Our ref: TH/TR/Q200773
Your ref: P21/05372/RM
Email: tim.rainbird@quod.com
Date: 4th October 2023

Town and Country Planning Act 1990 (as amended)
Plot 4 Land at Western Approach, Severn Beach, South Gloucestershire, BS35 4JX
Section 96a Non-Material Amendment to planning permission ref. P21/05372/RM
(dated 24th June 2022)
Submitted on behalf of BGO Wire Propco Ltd

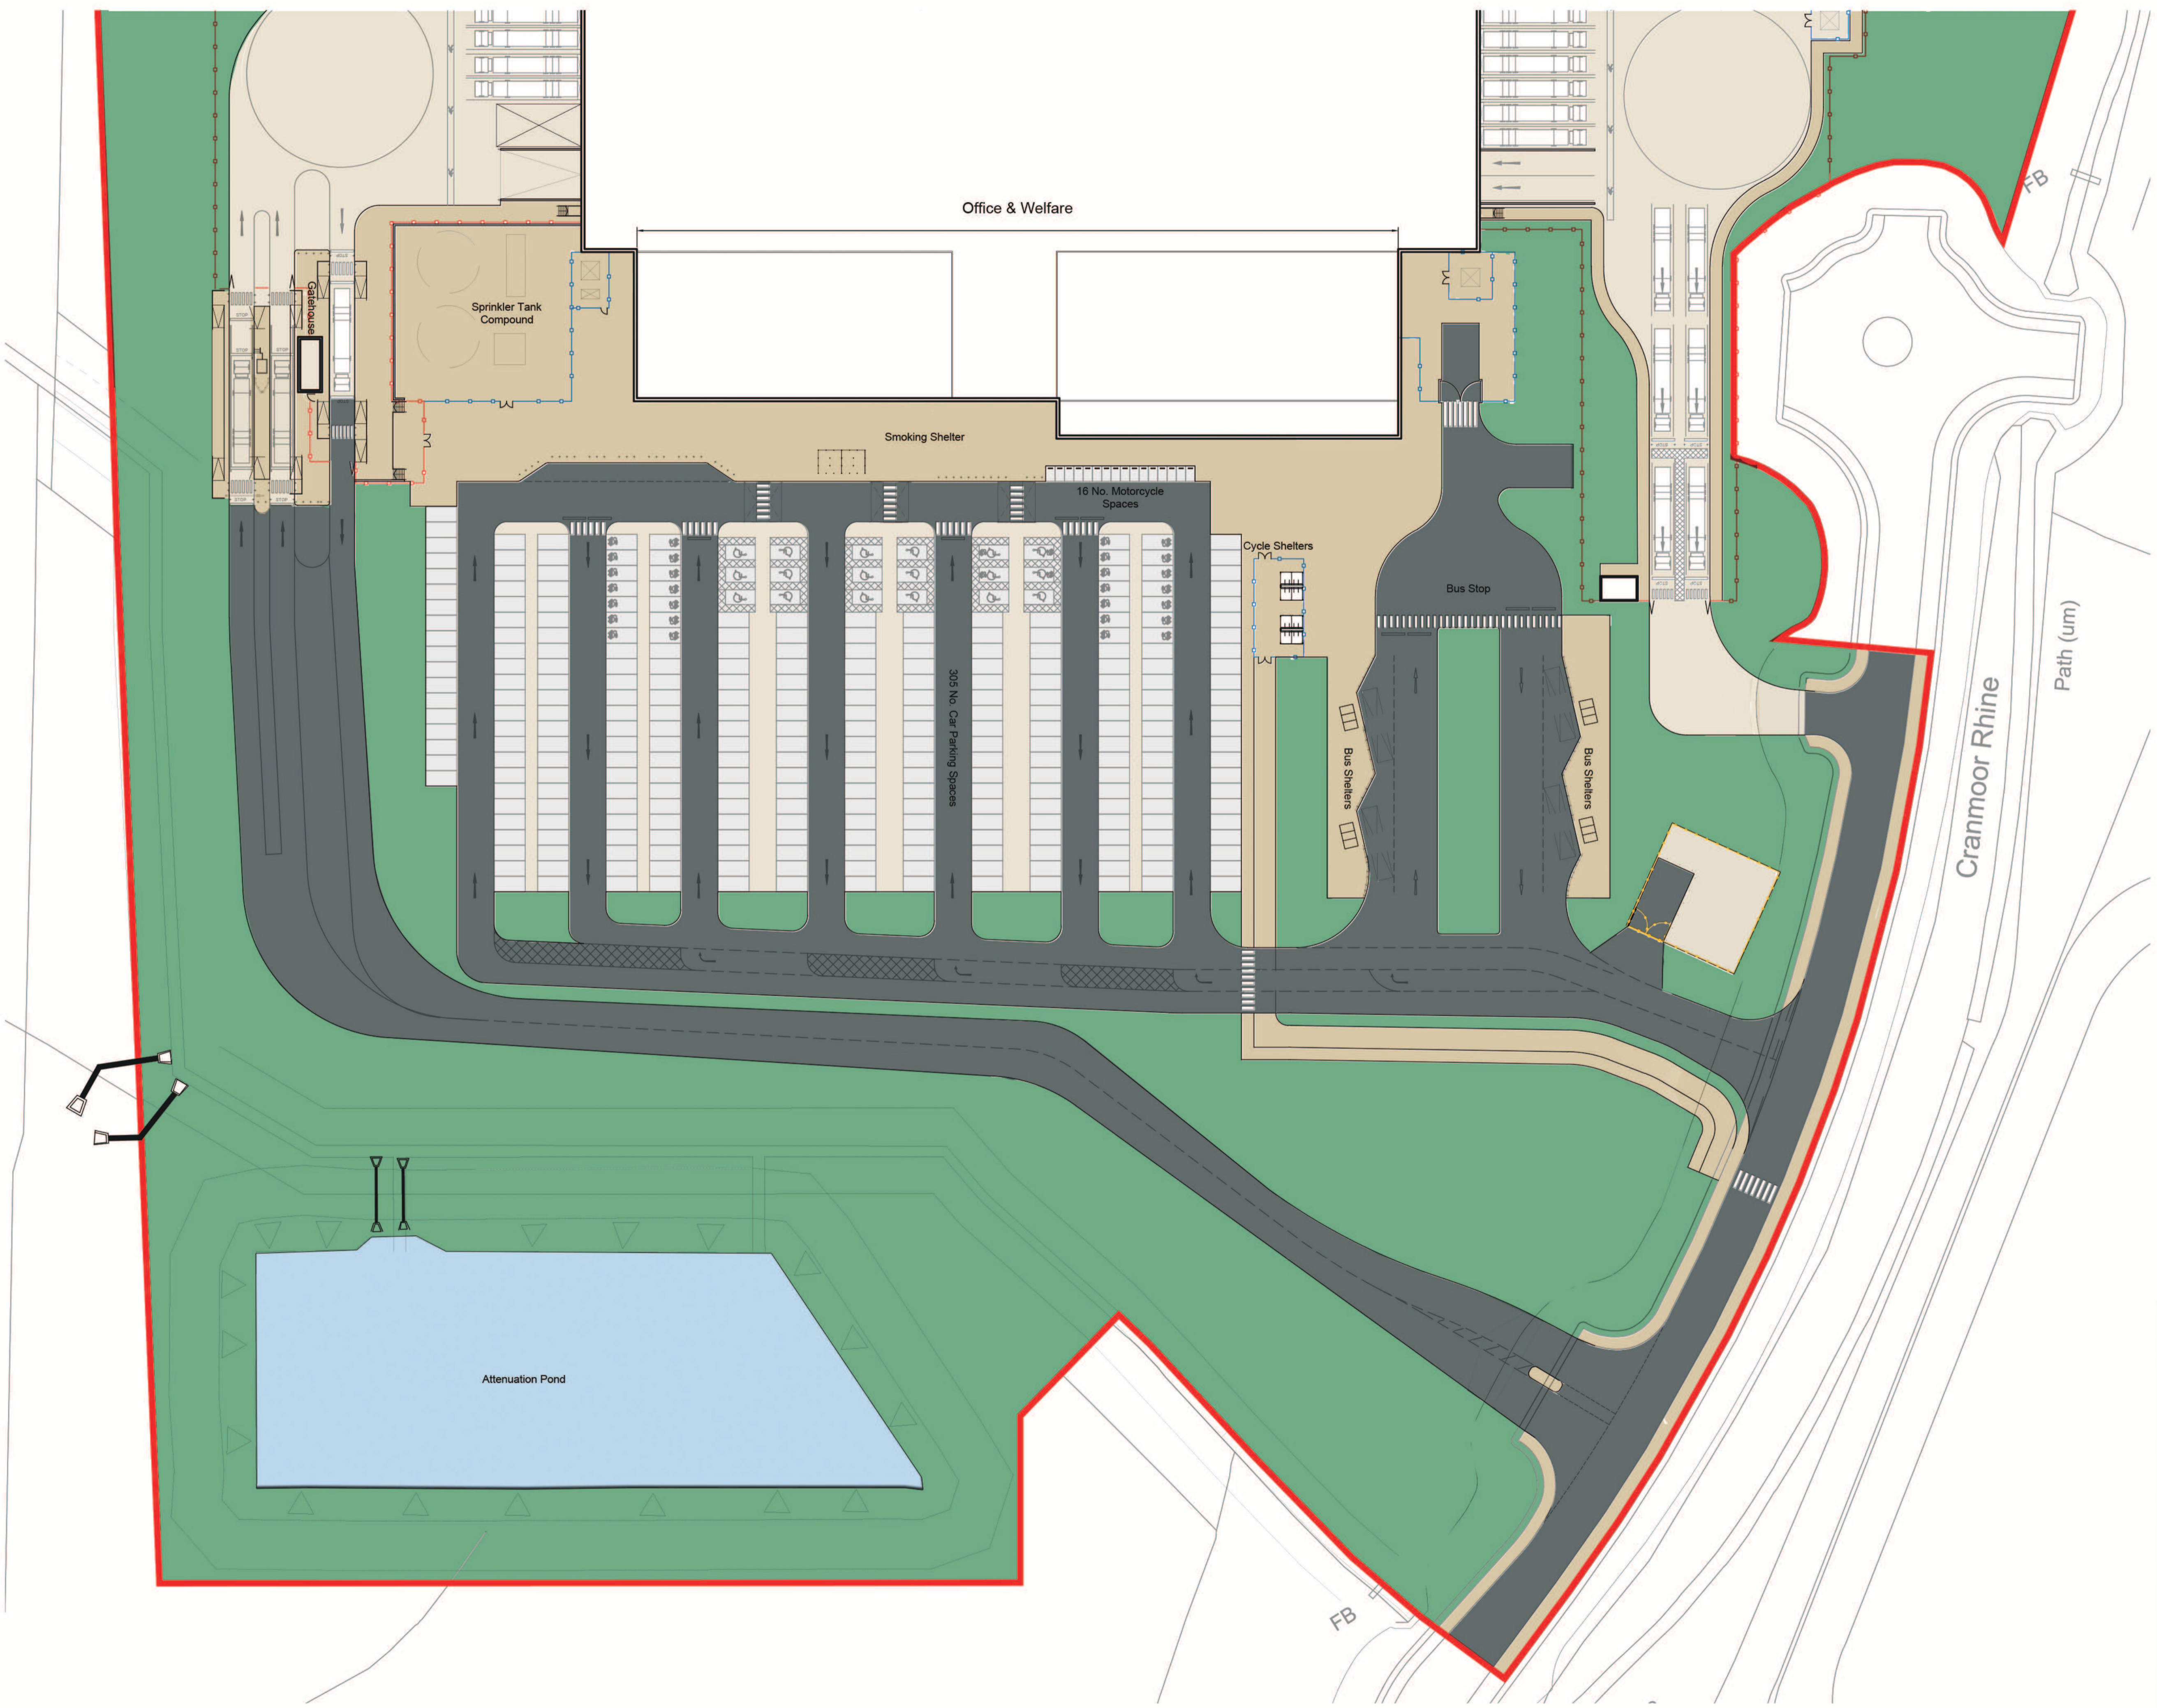
As indicated on the updated Proposed Site Plan (ref. 20341 P0102 G & 20341 P0103 D), the foul pumping station enclosure and surface treatments are now shown, along with a minor adjustment to the footprint of this area. Specifically, as shown on the submitted drawings, this area will be enclosed by a 2.4 metre high paladin fence and be part tarmac and part concrete. For the avoidance of doubt, no other changes are proposed to the approved layout.
